Submission for 132-138 Killeaton Street, St Ives, NSW

Larry, Sarah, Dylan, Ethan & Brayden Melnick (Melnick Family)

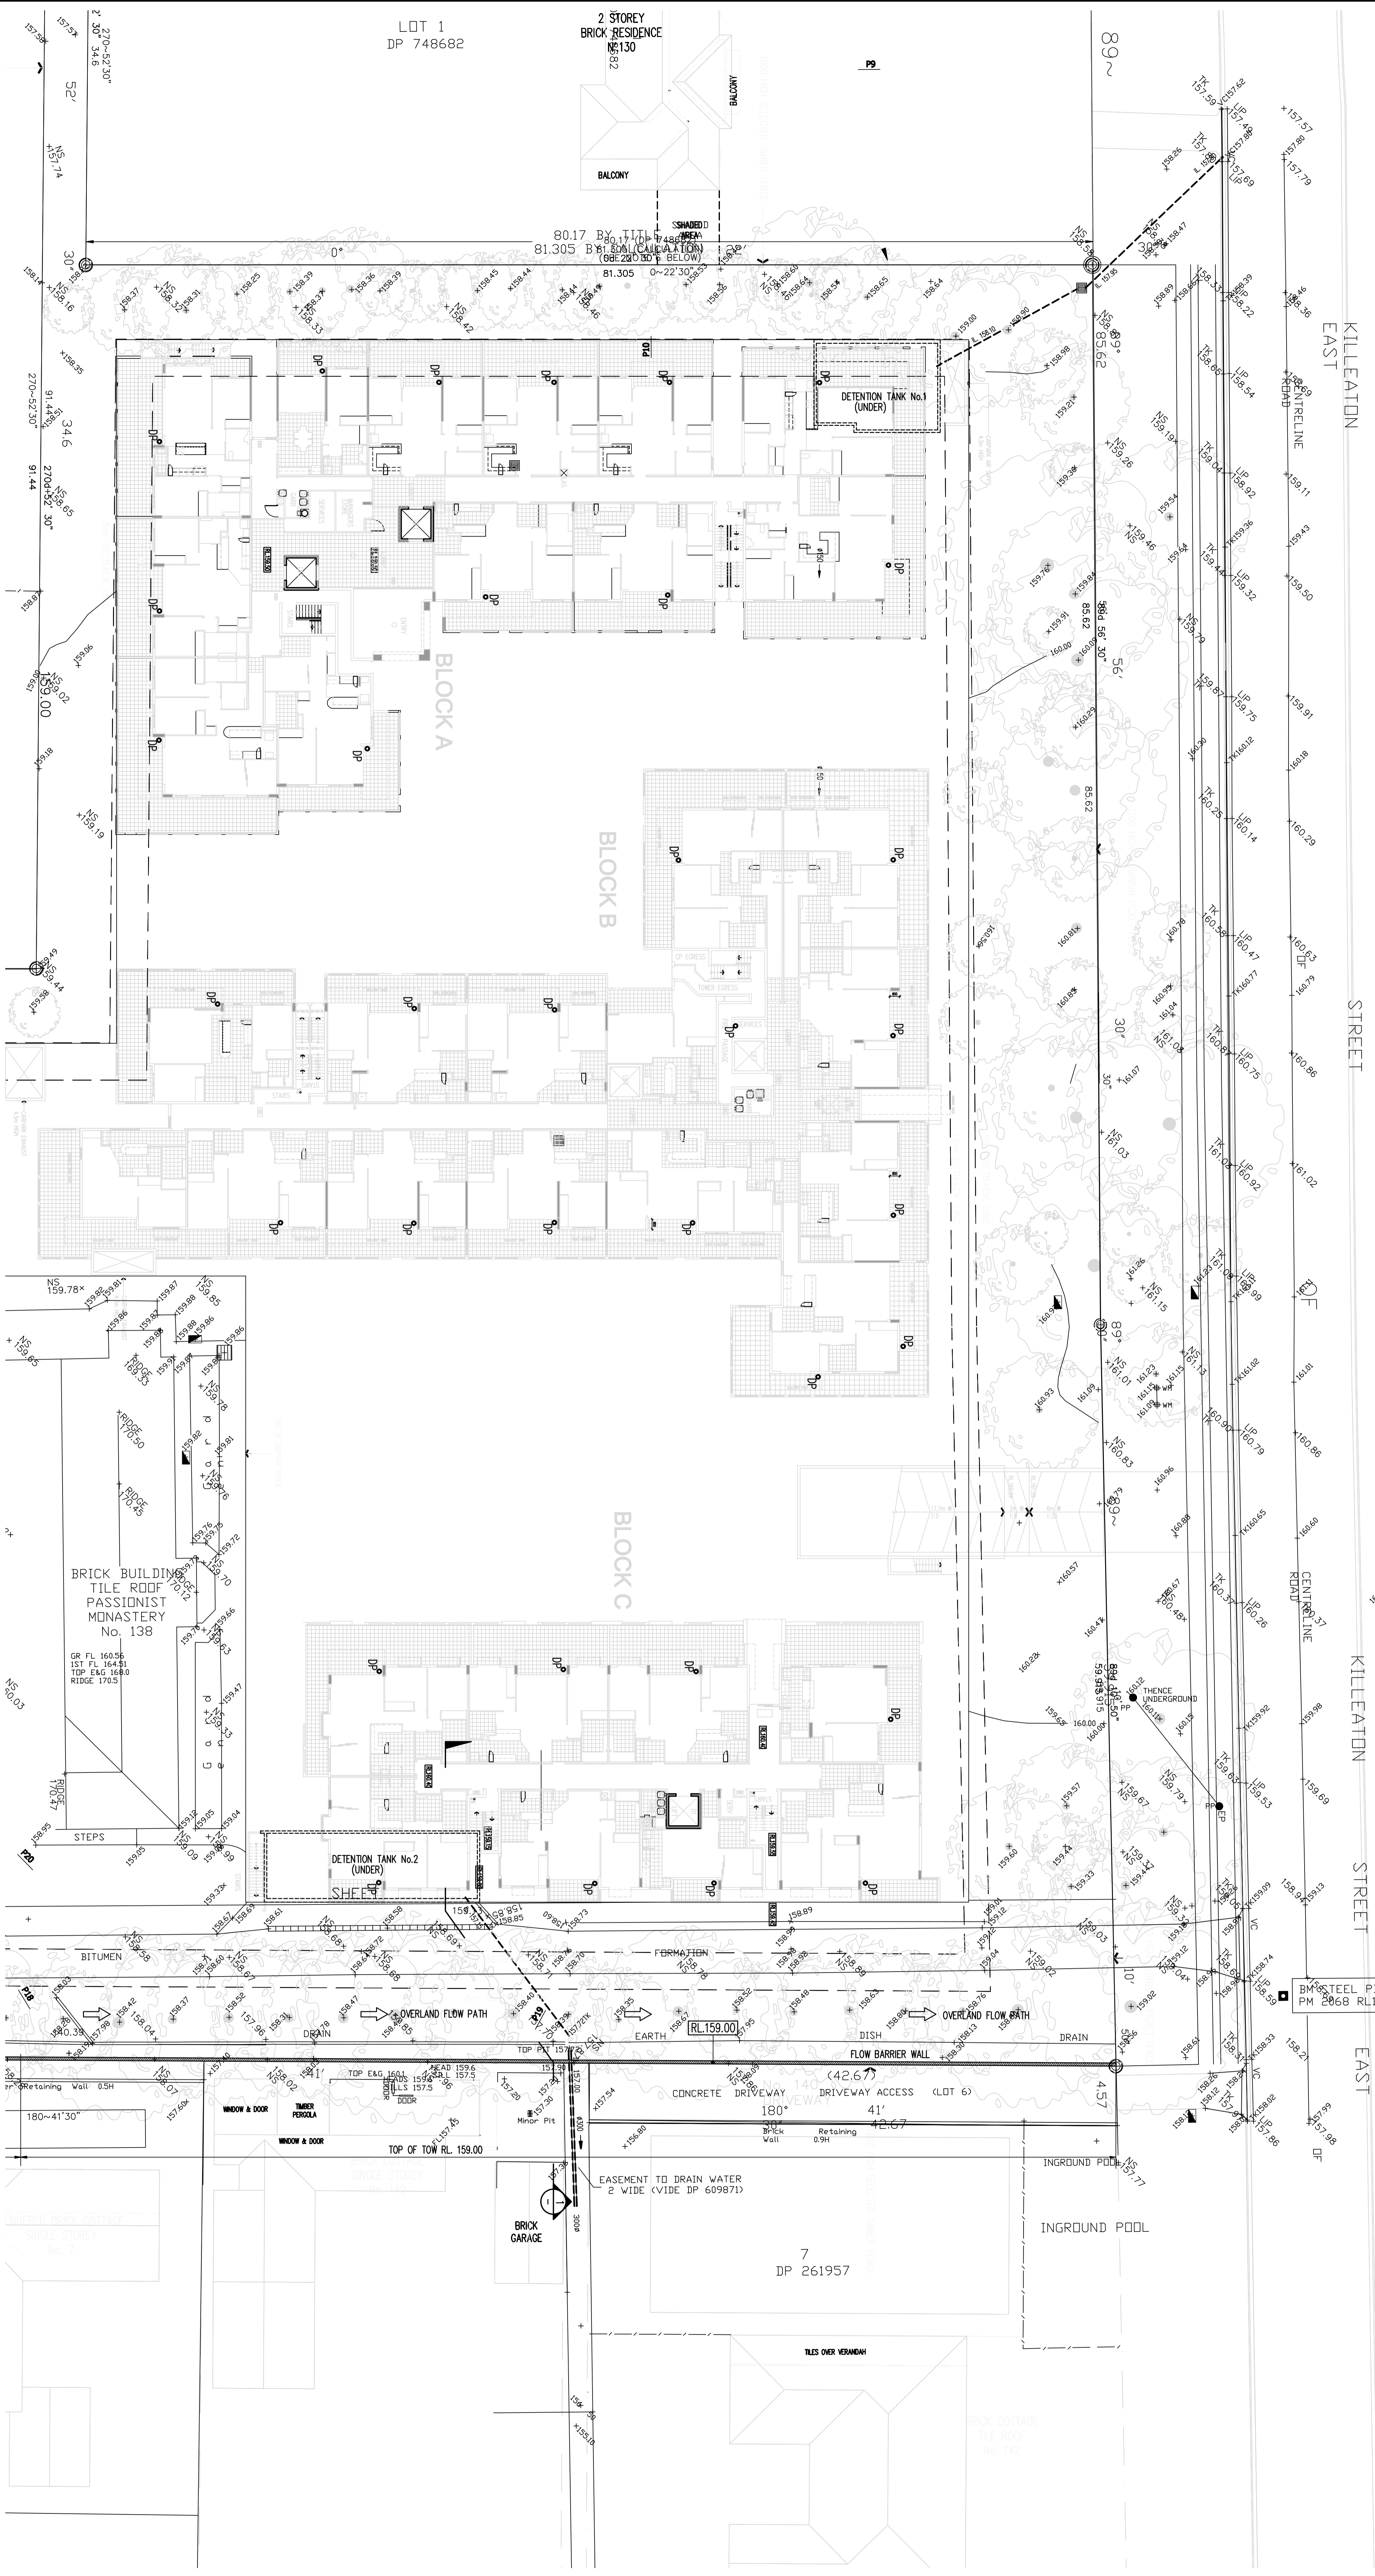
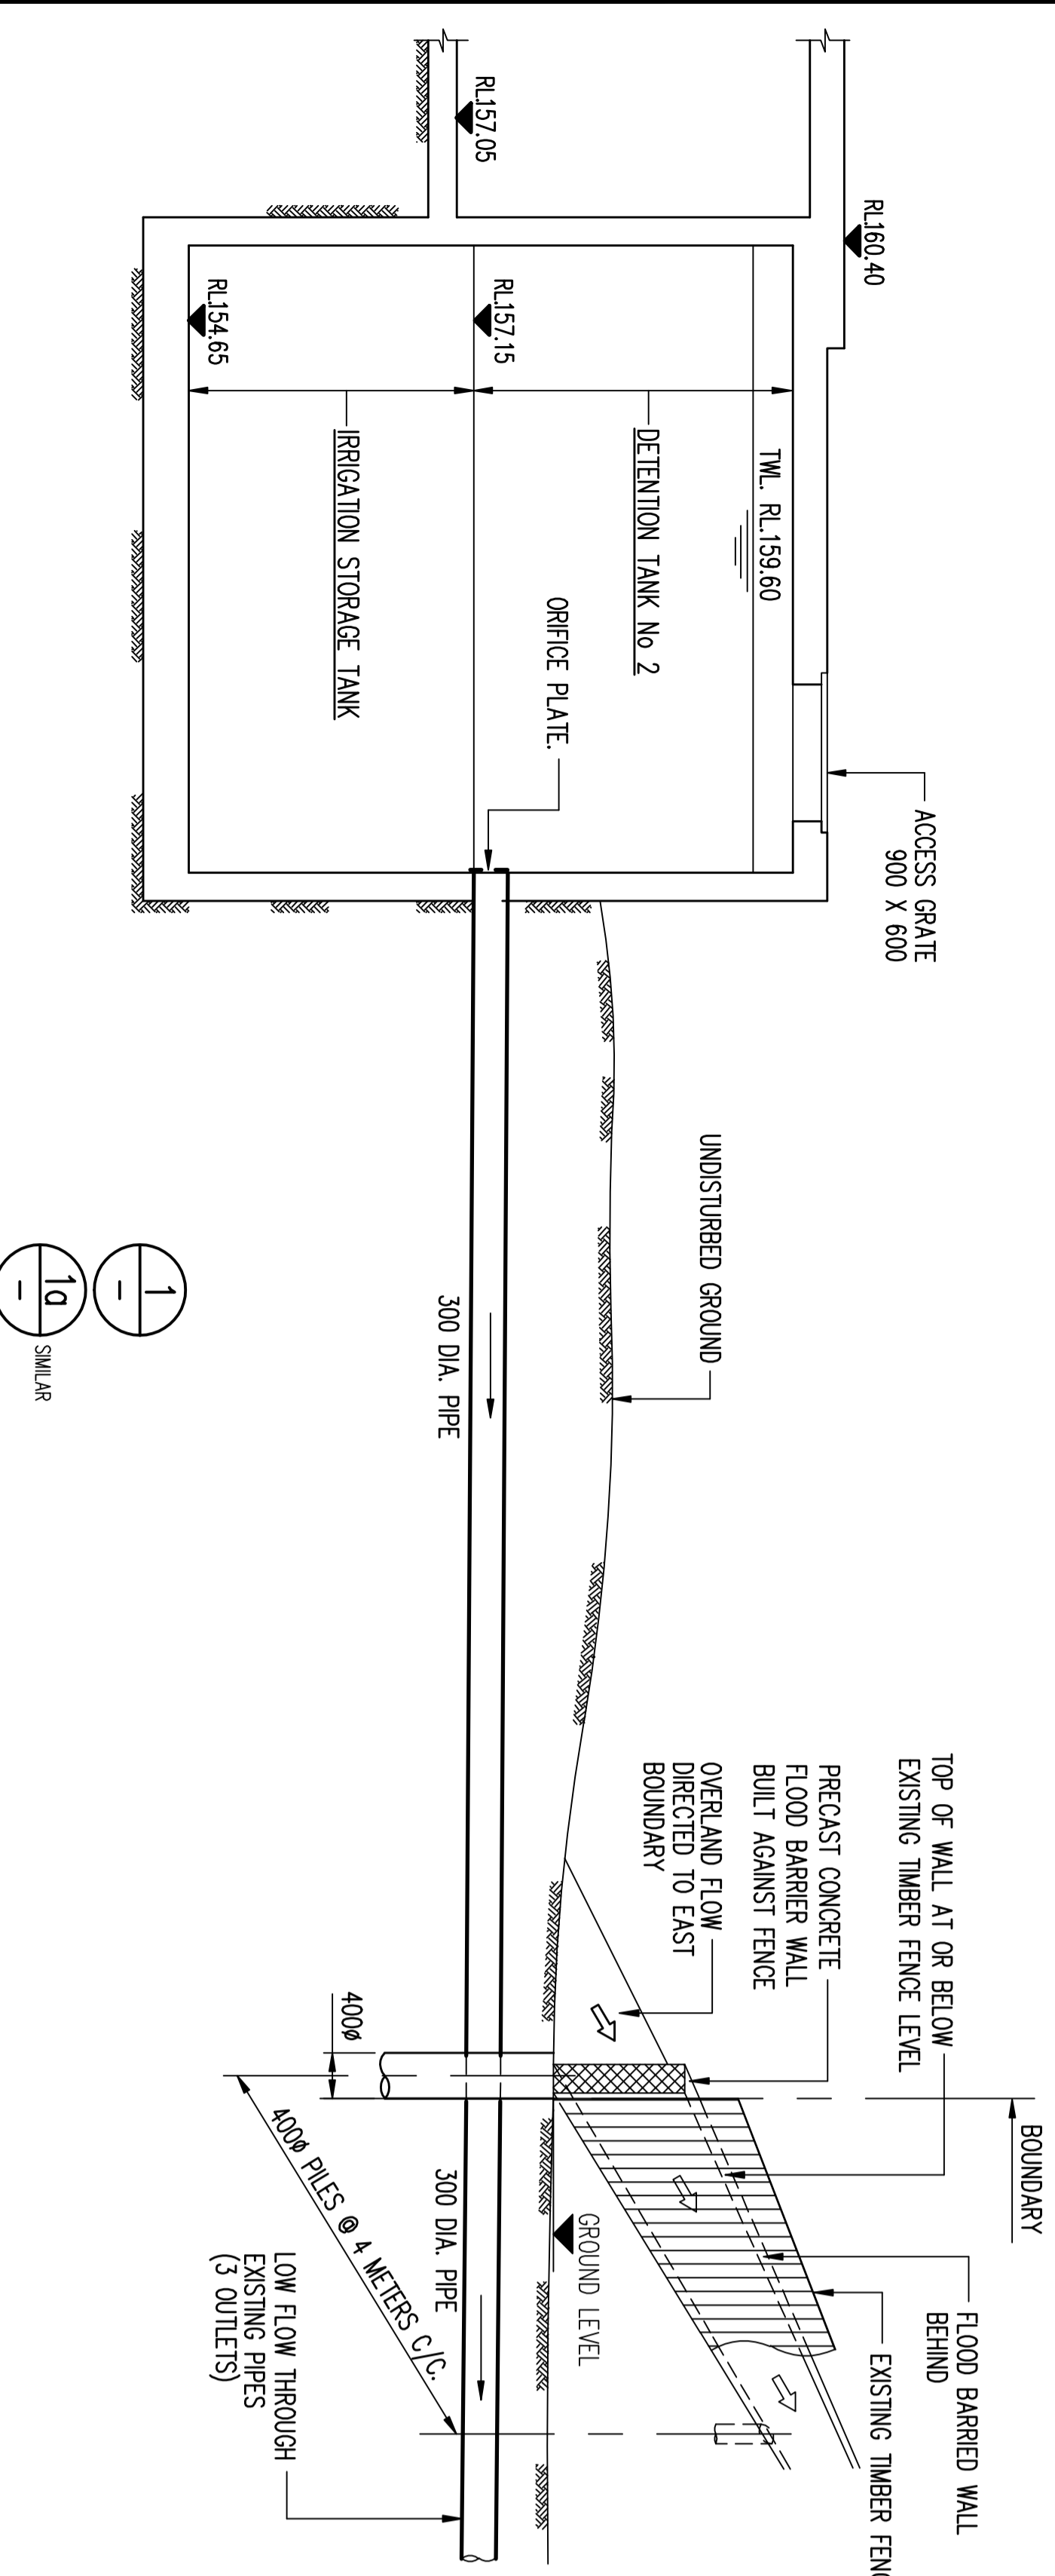
Stormwater runoff concerns		Due to the contrast of the existing contours of the proposed development site and the hardstand that will be created as part of the development and those residential dwellings located at lower contour points, the potential for flooding appears to be a significant issue which has not been adequately addressed in the drainage reports by Bonacci. The Crime Risk Assessment Report, dated June 2010, does not appear to adequately address potential terrorist activities given the proximity of the block located directly adjacent to Masada College and the existing sensitivities on this matter.
Safety and welfare of nearby schools
